Hearing Transcript

Project:	Dogger Bank South Offshore Wind Farms
Hearing:	Issue Specific Hearing 2 (ISH2) – Session 6
Date:	16 January 2025

## Figure 20-2-1 Geomorphology Survey Locations

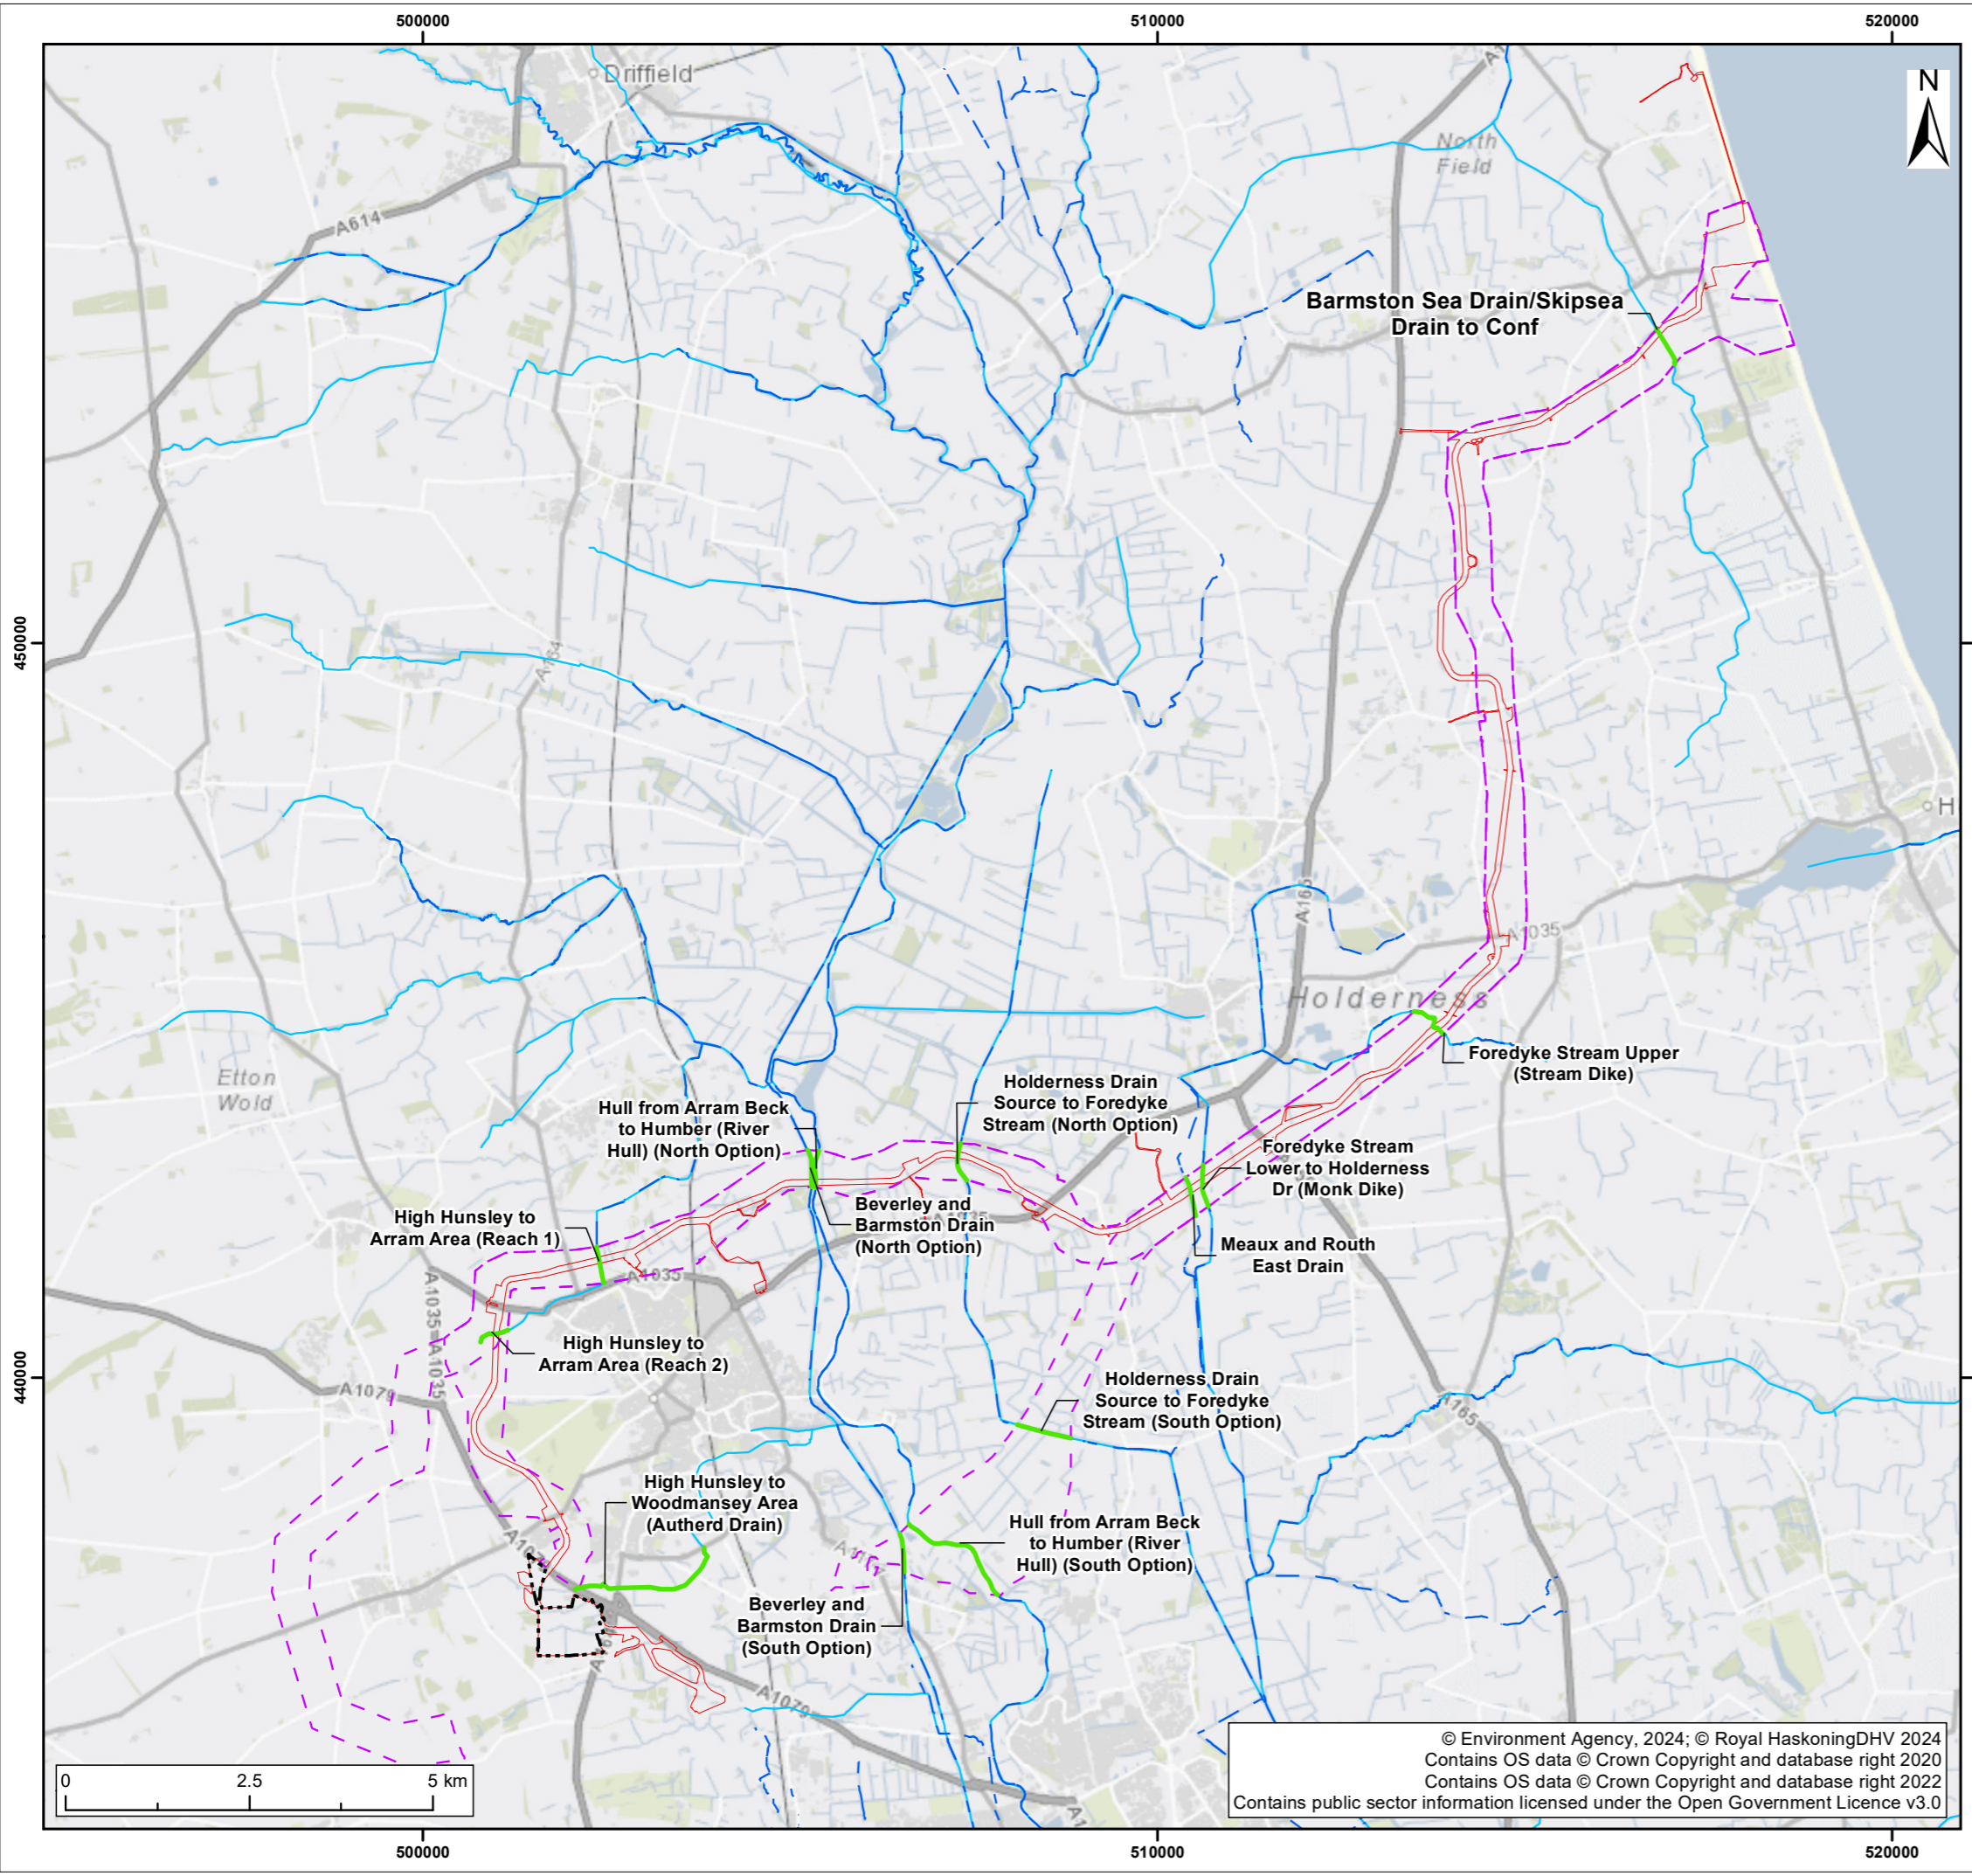
yes, thank you. I shall start with 11.1, which is related to the scope of the geomorphological survey, and with this specific regard to its spatial extent and included water courses, it probably useful if we could have figure 22 one of the geomorphological survey report, which is a PP 166, on the screen, Please.

Whilst you're doing that, I'll just describe the issue I'm looking to explore. So this figure is based upon the corridor routes which were relevant at the primarily environmental impact report stage. And it's not clear if the onshore development areas outside of the survey extent have subsequently been surveyed. And this will become obvious when we can see the figure on screen. I'd like the applicants to confirm if the areas outside of the survey extent have subsequently been surveyed or not. Sarah,

yeah, that's fine. So, so not far from where you're pointing now, of the cursor, just slightly further south, you can see there's an area which is outside of the survey extent. Am I sort of simply want to know whether that has subsequently now been surveyed or not.

there. Okay, so as the first action point, then, could you come back to the examining authority to confirm there aren't any water courses of interest within the area that doesn't appear to have been surveyed. I

That's fine, and you're sort of leading into where I'm going next, which is, if you could just explain why the survey was limited to 13 major water courses, and then subsequently, were there any water courses which haven't been surveyed? How have they therefore been assessed as part of this?

which sections you're meaning? I can see the green areas are where it was surveyed, and obviously they're more extensive than the red line boundary. That is the case because obviously the project area has been refined down as time has gone on, and the sort of peer boundary when this survey was done, yeah, was more extensive so that those green areas were surveyed. Yeah,

Um, that doesn't look like there's any water courses there. So if it wasn't in the peer boundary at the time of the survey, No, it wouldn't have been surveyed. But it doesn't look like there's any water courses

will just state as well that the figure shows environment EA, main rivers and river water bodies assessed under the water environment regulations, and that was the scope of the survey, because they are that's potential disturbed statutory features, which are main rivers, or the potential to cause deterioration to river water bodies. And as you can see, there are no river water bodies or ear men rivers in that area, so we wouldn't have surveyed that at the time.

Yeah, the. Scope was defined on, as I said, assessing statutory features on the river water bodies. Or it's just worth to point out that all of the water bodies in this area are either artificial or heavily modified, because they're sort of being modified for land drainage or flood defense, and the other sort of ordinary water courses, drains, ditches, what have you that cross the corridor are basically the same sort of features this area is sort of like historically drained. And as you can see by the regular sort of pattern of

channels. There were a lot of channels there, and I'm very confident if you were to survey all of those, it wouldn't really change the baseline, because we're looking at a sort of set of parameters described in the appendix, 20.2 things like floor, sediment, floodplain connectivity, okay, and those features are basically similar for the channels that we surveyed, and those that those sort of small loss riparian ditches that haven't been surveyed.
